From: Planning
Subject: FW: Planning Application Comments - 3/2023/0844 FS-Case-563454750

Planning Application Reference No.: 3/2023/0844

Address of Development: 5 Whalley Rd Read BB12 7PB

SIDE ELEVATION [No.3] - 1:100 at A3

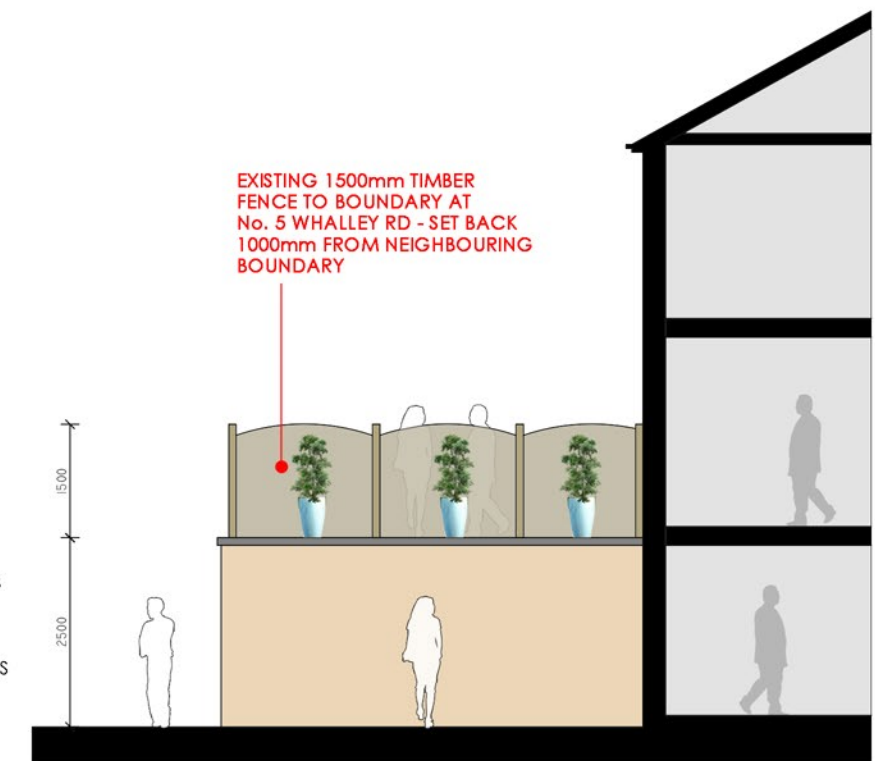
Comments: On Behalf of the Read Parish Council we wish to object to the retrospective planning permission. The original plan was for a glass balustrade, and a wooden fence has been erected instead. This causes loss of light for the neighbour and is also against the Ribble valley Core Strategy DMG1 and DMH5.
